Development Control
Ribble Valley Borough Council

Your ref: 24.0898
Our ref: D3.24.0898
Date: 5th December 2024

Address: Field to the south of Clitheroe Road and east of Cow Ark Brook, Cow Ark

Proposal: Engineering works to create four wetland ponds, ditches and banked hedges.

Cow Ark Wetland Location

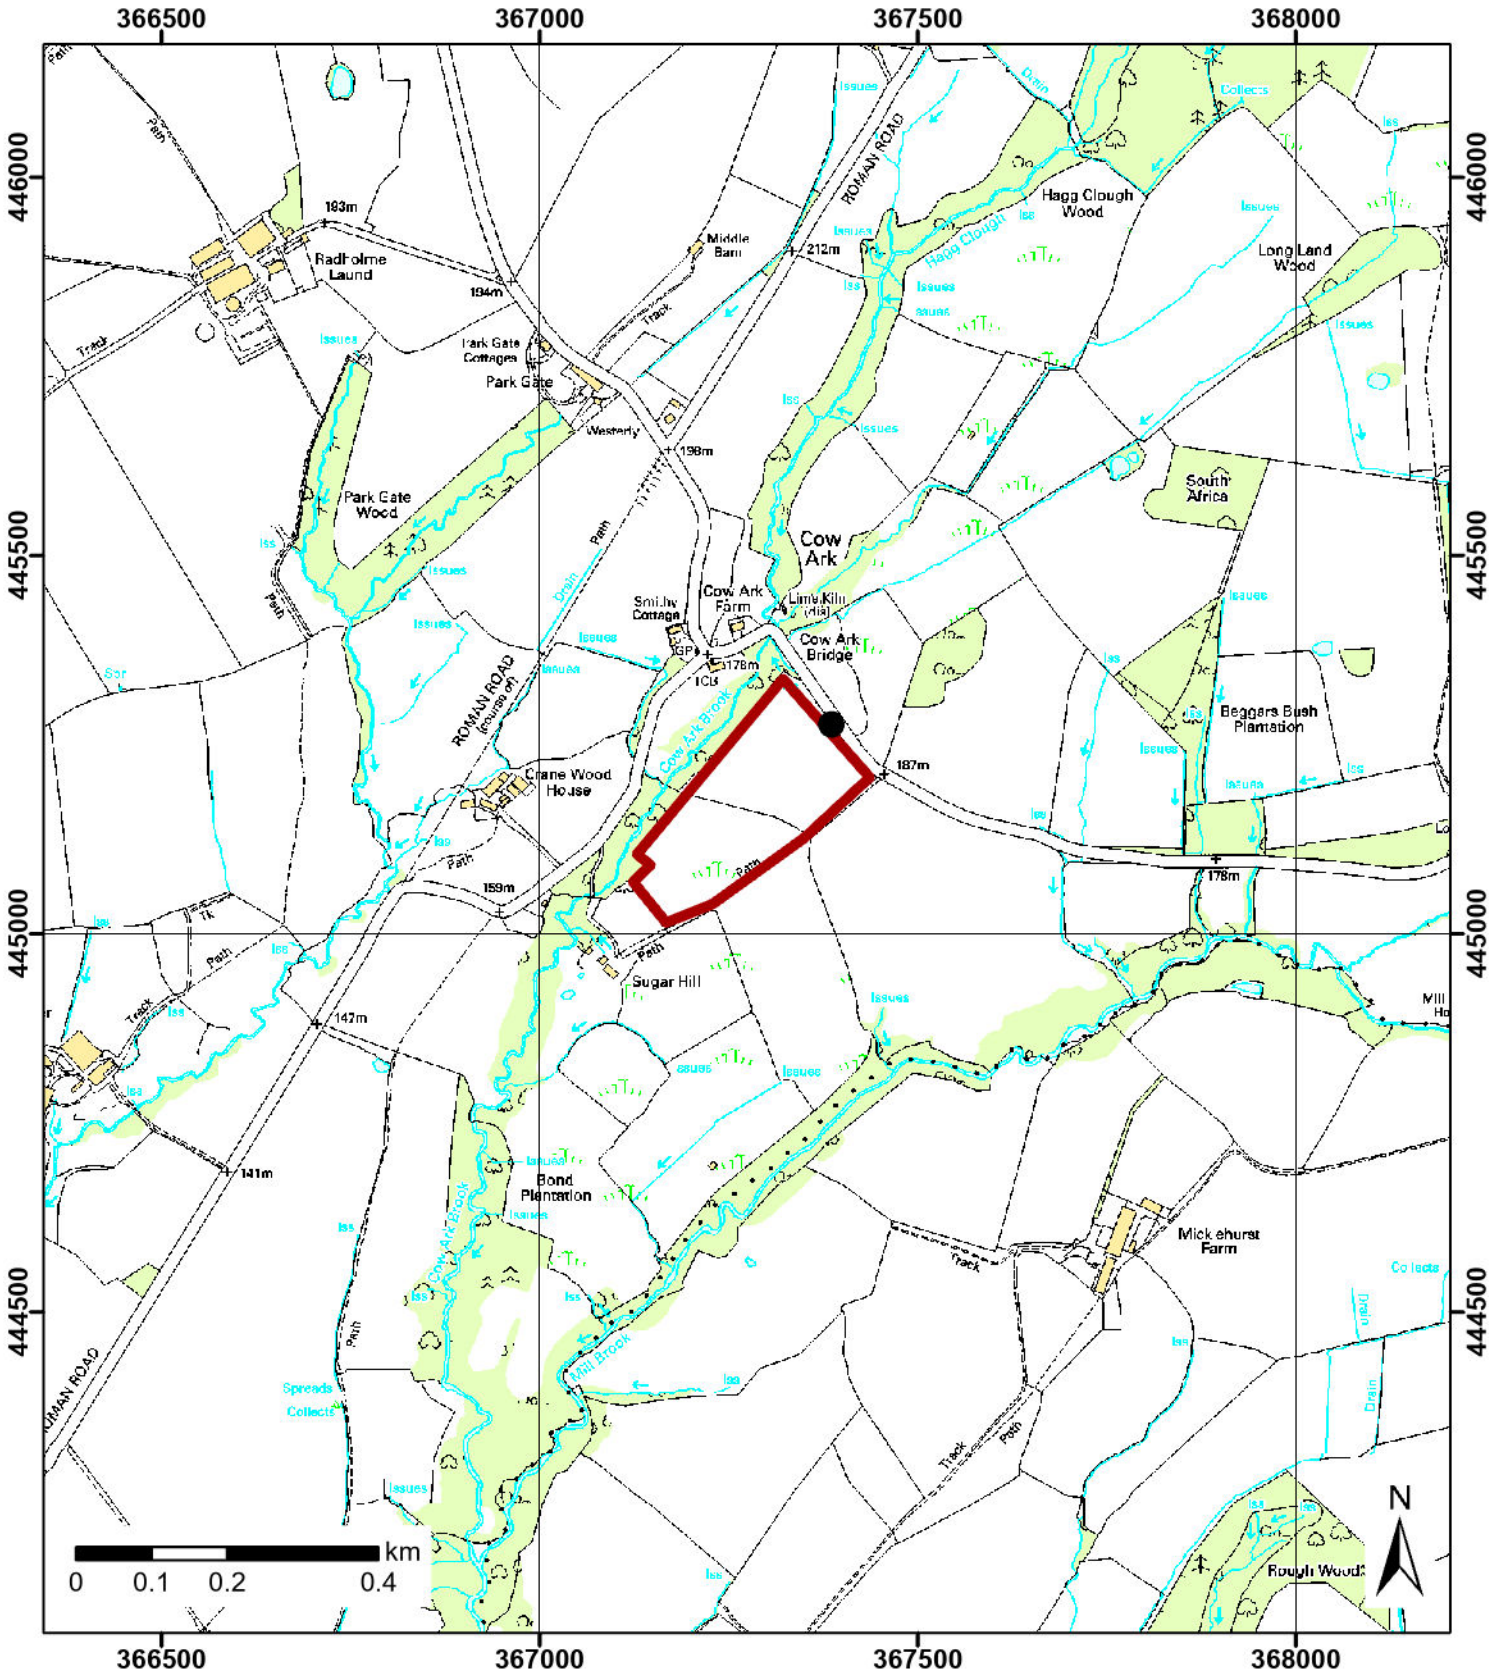
Details are requested to be submitted regarding where vehicles will access the site, details of the site access arrangement and details of the size and frequency of vehicle movements through the site access. Subject to the site access and vehicle movements, we may require details of internal turning areas to be provided and wheel washing.
